ABP-320705-24 (Knockshanvo Wind Farm & 110kV Substation)

VA03.320727 / ABP-317763 (110kV Grid Connection & Subsurface Cabling)

Date: 4th August 2026

We are writing to submit a formal observation directly responding to the planning statements and response to observations submitted by the applicant, FuturEnergy Knockshanvo DAC (prepared by MKO).

**SHEET TITLE**

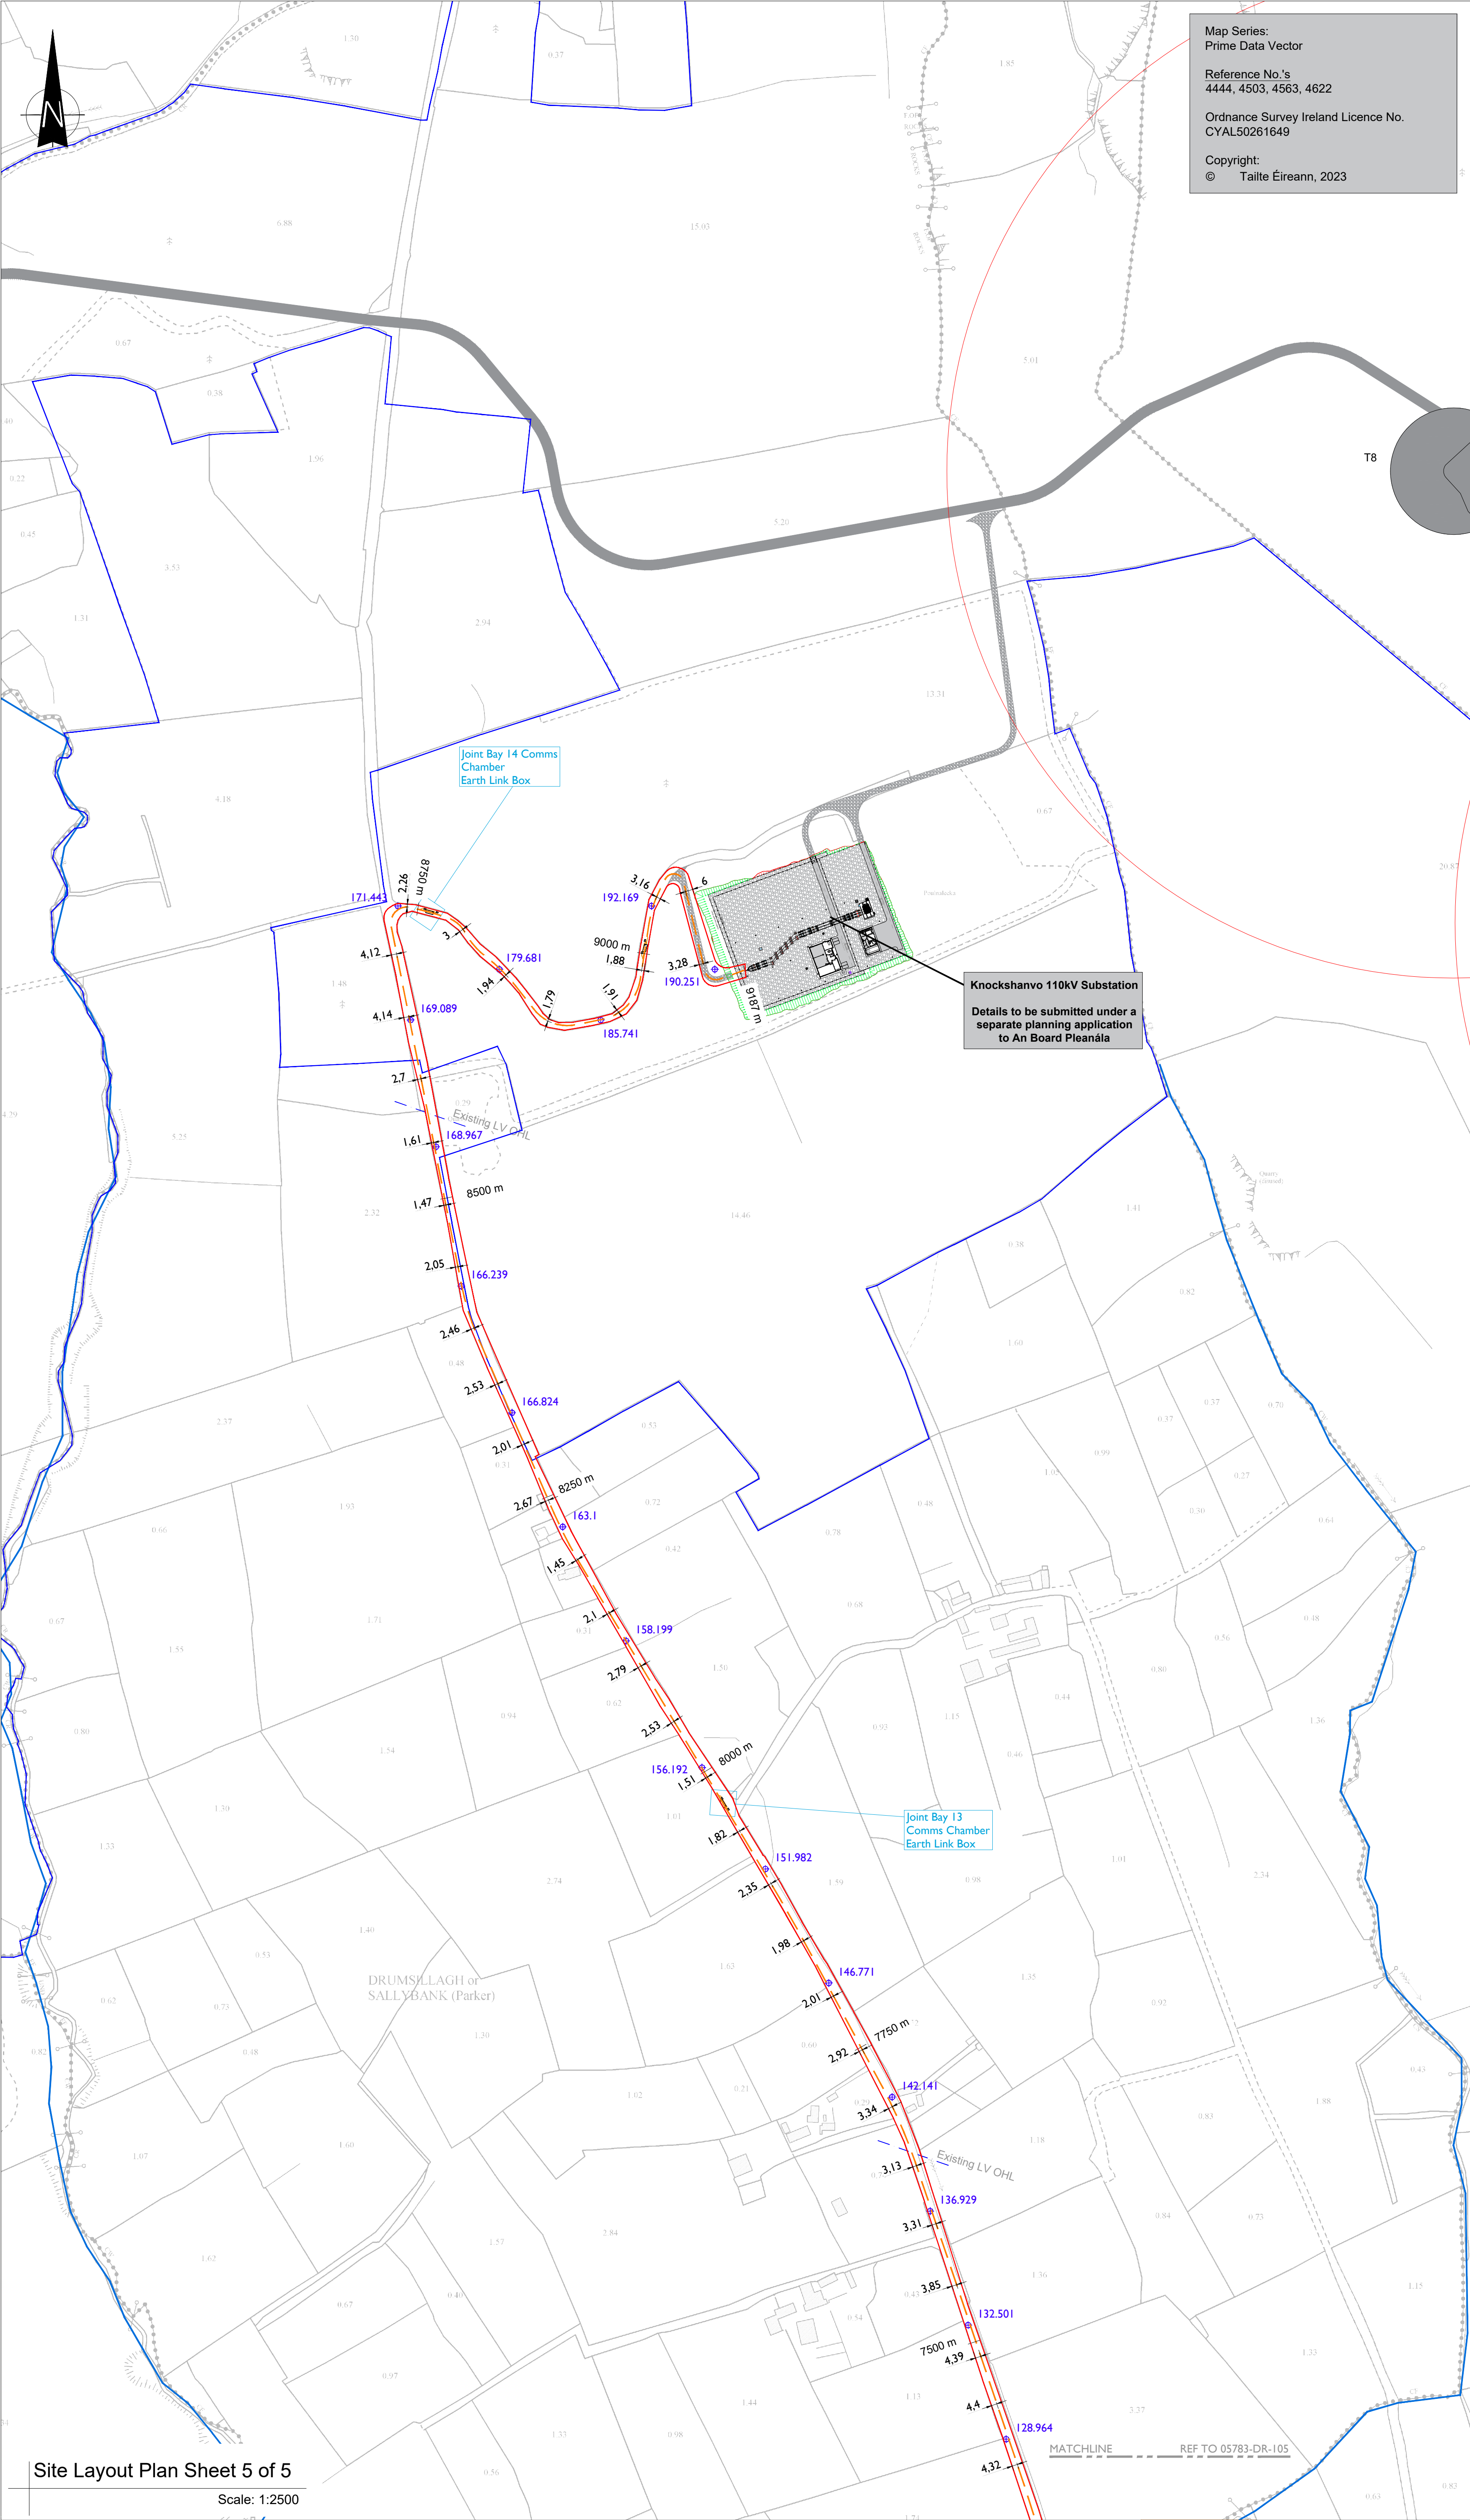
As the side wall of our house forms the direct boundary line flush with Sallybank Road, heavy industrial rock-breaking, excavation, and deep trenching will occur in very close proximity to our home's primary load-bearing walls.

While MKO promises to restore the public road tarmac for Clare County Council, they have provided zero localized structural engineering assessments, zero baseline structural surveys, no vibration monitoring protocols, and no structural indemnity framework to protect our home against catastrophic cracking or subsidence.

Sallybank Road (L3042) is a highly constrained, narrow country lane where two passenger cars cannot consistently pass. Digging an open high-voltage trench while operating heavy industrial plant machinery will physically consume the entire road width outside our gate. The developer has provided no engineering methodology proving how a passable lane can be physically maintained. This layout cuts off our right of way, trapping us inside our property or barring access home, particularly when works are ongoing outside of our property.

Furthermore, as raised in our original submission, we reject the applicant's unfounded assertion that subsurface cable trenching along Sallybank Road (L3042) will progress seamlessly at 100 meters per day to complete in "one month". The applicant's response document provides zero technical or engineering methodology to substantiate this rate of progress along a narrow, constrained country lane. Given that our property sits 3 km along this single-lane corridor, the developer's reliance on generalized post-consent Traffic Management Plans (TMPs) fails to address real-world construction delays, physical road blockades, or how daily residential and emergency access will be physically guaranteed over what will inevitably be a far more prolonged and disruptive timeframe.
